Re: Galway County Council (N63 Abbeyknockmoy Village Active Travel) Compulsory Purchase Order
No.4 2025
In the townlands of Cullagh South and Cullagh North, Abbeyknockmoy, County Galway

**GALWAY COUNTY COUNCIL (N63 ABBEYKNOCKMOY VILLAGE ACTIVE TRAVEL)
COMPULSORY PURCHASE ORDER NO. 4 2025 (PHYSICAL INFRASTRUCTURE, FIRE
AND EIMEARGENCY SERVICES AND CLIMATE CHANGE)**

**AN COIMISIÚN PLEANÁLA
CASE REFERENCE - CH07.323535**

Project Name: LA12/23 Part 8 Application for Active
Travel scheme in Abbeyknockmoy Village

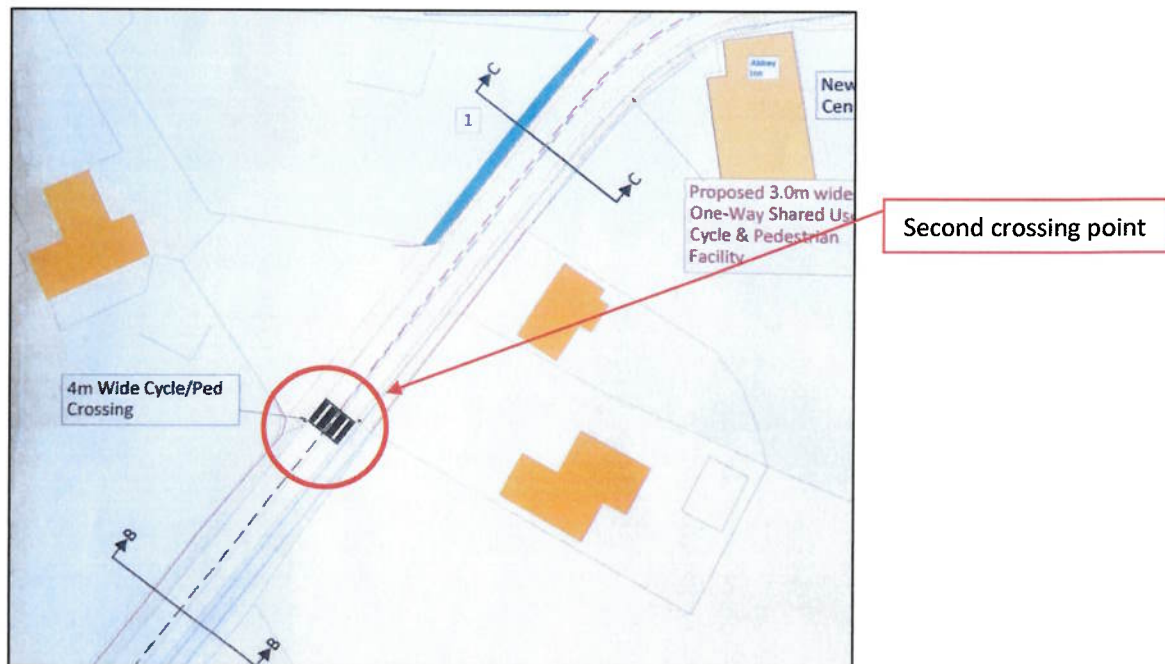
Our clients consider that a second pedestrian crossing point should be provided at the western side of the village. The proposed development is being designed in accordance with the Design Manual for Urban Roads and Streets (DMURS). DMURS acknowledges that pedestrians will follow the desire line (i.e. take the shortest route), even if this conflicts with the location of formal crossings and pedestrian control measures. DMURS also identifies that well designed and frequently provided crossings are critical to the balancing of movement priorities, the design of crossings, and the frequency at which they are provided, will have a significant impact on pedestrian/cyclist mobility and comfort and the flow of vehicular traffic and that the location and frequency of crossings should align with key desire lines and be provided at regular intervals.

The provision of a second raised pedestrian crossing on the western approach to the village would align with the principals of DMURS and would greatly assist in the reduction of speed of vehicles approaching the village from the west. This would provide a similar level of provision in other recently completed active travel measures in local villages, such as Barnaderg where the introduction of a raised pedestrian crossing on both sides of the village core has greatly reduced traffic speeds.

The need for a second crossing was clearly identified by the local authority and was included in the earlier draft design proposal for the scheme. Our clients feel that it is incumbent on the local authority to include a second pedestrian crossing on the western side of the village. This would encourage a reduction in traffic speeds on this section of roadway and give some piece of mind to current residents, pedestrians, and cyclists.

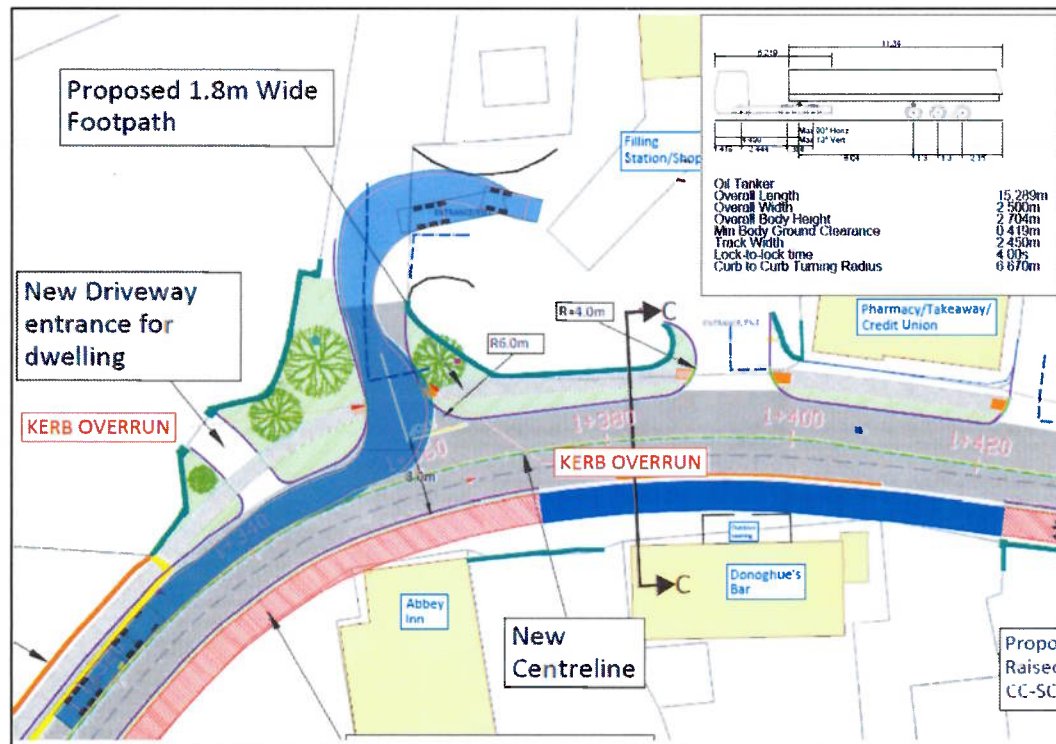
The proposed design will result in a significant loss of parking spaces which serve the existing businesses in the village. The loss of parking spaces includes the loss of 6-7 spaces to the front of the credit union/takeaway/pharmacy retail units, 3-4 spaces to the front of the petrol filling station forecourt and the loss of 4-5 spaces to the front of the public house/dwelling. Potentially up to 15-16 parking spaces will be lost as a result of the scheme. Many of these spaces are regularly used as pick up and drop points for the many buses serving the village, including for school pickup and drop-off.

The loss of the existing roadside car parking spaces will undoubtedly lead to customers parking within the petrol station forecourt. This will reduce the space available for customers wishing to access our client's petrol station forecourt, convenience shop and post office. The increase in traffic and parking within the forecourt area will give the impression that forecourt is busier than may be the case thereby discouraging passing motorists from entering and using the business. This will have a significantly negative impact on our client's business. It will also give rise to increased traffic congestion within the site and increase the potential for accidents.

The parking area to the front of the petrol filling station and retail units is used as a pickup point for school busses serving Holy Rosary College, Mountbellew. Two busses serve the school and pick up students each morning in the village. Both buses park for fifteen minutes during pick-up. Our clients consider that the proposed provision of on street bus stops is not suitable or adequate to accommodate these school busses.

Extract from drawings No. P8-N63AT-LP-03

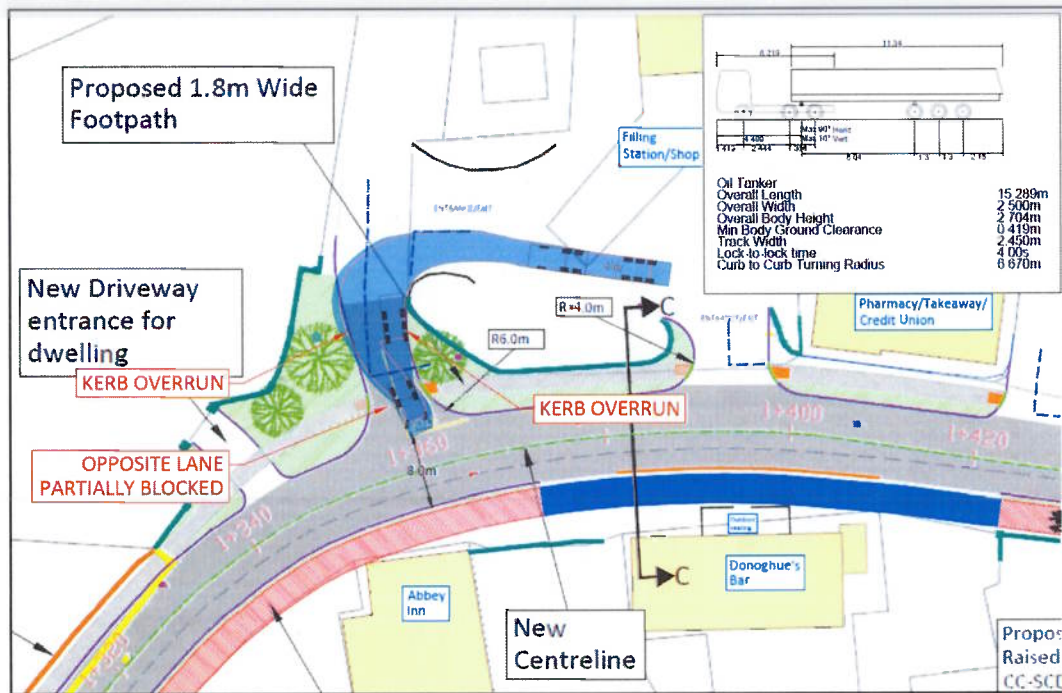
The petrol filling station regularly receives fuel deliveries by means of articulated fuel tanker and the shop deliveries are carried out by articulated truck. The petrol filling station also serves a large number of HGV & bus customers. The proposed alterations to the L2128 junction will significantly impact on heavy goods vehicles (HGV) entering, exiting & using the petrol filling station/shop.

As an example of the deficiency in the design proposal swept path analysis for an oil tanker entering and exiting the site via the L2128 junction are outlined below. They clearly indicate that it will not be possible for an oil tanker to access and leave the petrol filling station without overrunning the kerbs in a number of locations and completely crossing over the oncoming traffic lane on the L2128 roadway. It is not possible for the tanker to manoeuvre into position at the stop line without partially blocking the opposite lane. This will cause a traffic obstruction and have the potential to cause collisions.

It will not be possible for a fuel or other delivery trucks to safely access the petrol filling station/shop if the proposed alterations are carried out as planned. The proposed alterations to the L2128 junction taken together with the loss of parking spaces to the front of our client's dwelling house and across the frontage of the petrol filling station will significantly reduce the access to our client's business for HGV drivers.

We would ask that the proposal is given proper consideration in this regard and that all vehicle types which currently access the site, or could reasonably be expected to access the site, are considered and accommodated in order to minimise the negative impacts on our client's business.

Existing delivery area for public house

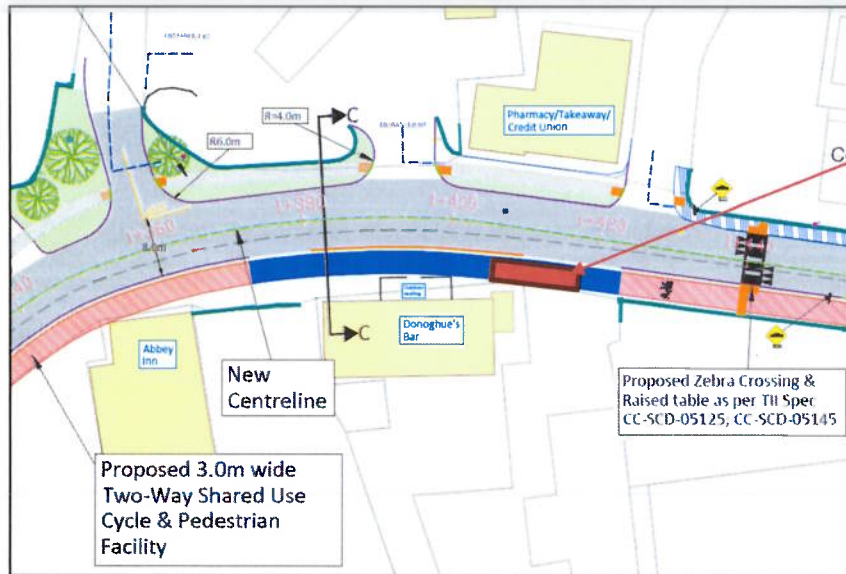
The proposed design will result in the loss of the existing parking and delivery area to the front of O'Donohoe's public house. This area has been used as a delivery area to accommodate articulated truck deliveries for four generations. The proposed double kerb arrangement between the road edge and shared surface will make it impossible for an articulated delivery truck to safely park and offload deliveries. It does not appear that the loss of this delivery area or how deliveries can take place to the public house has been considered in the design.

We would ask that this element of the proposal is redesigned to accommodate access for deliveries to the public house.

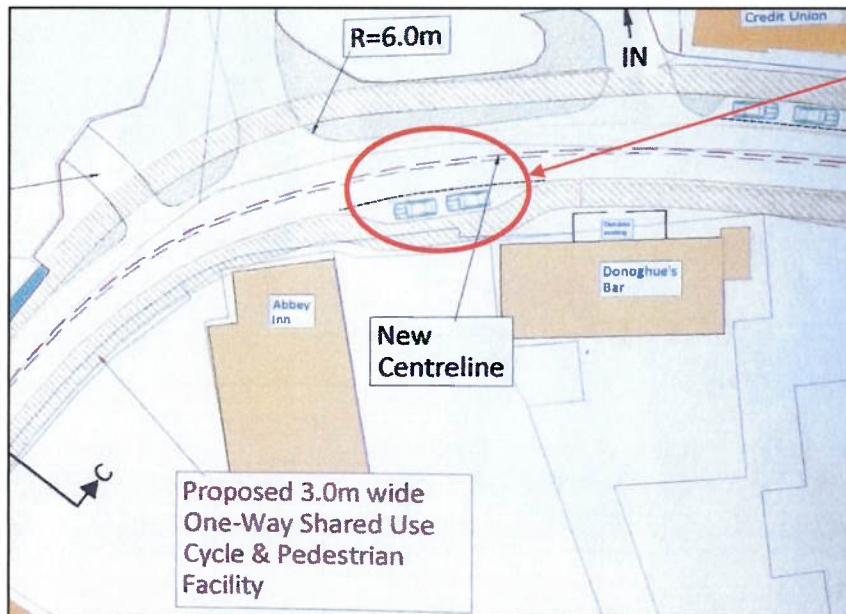
We note that the proposed design will result in the loss of the existing parking spaces to the front of the residence located above O'Donohoe's public house. It is considered that the design of the shared surface across the front of the public house and residence may unduly restrict access to the dwelling house and impact on the existing long established parking spaces serving the residence. The need for parking spaces in this location was identified and included in the draft plan.

We do not feel that this has been afforded sufficient consideration in the proposal.
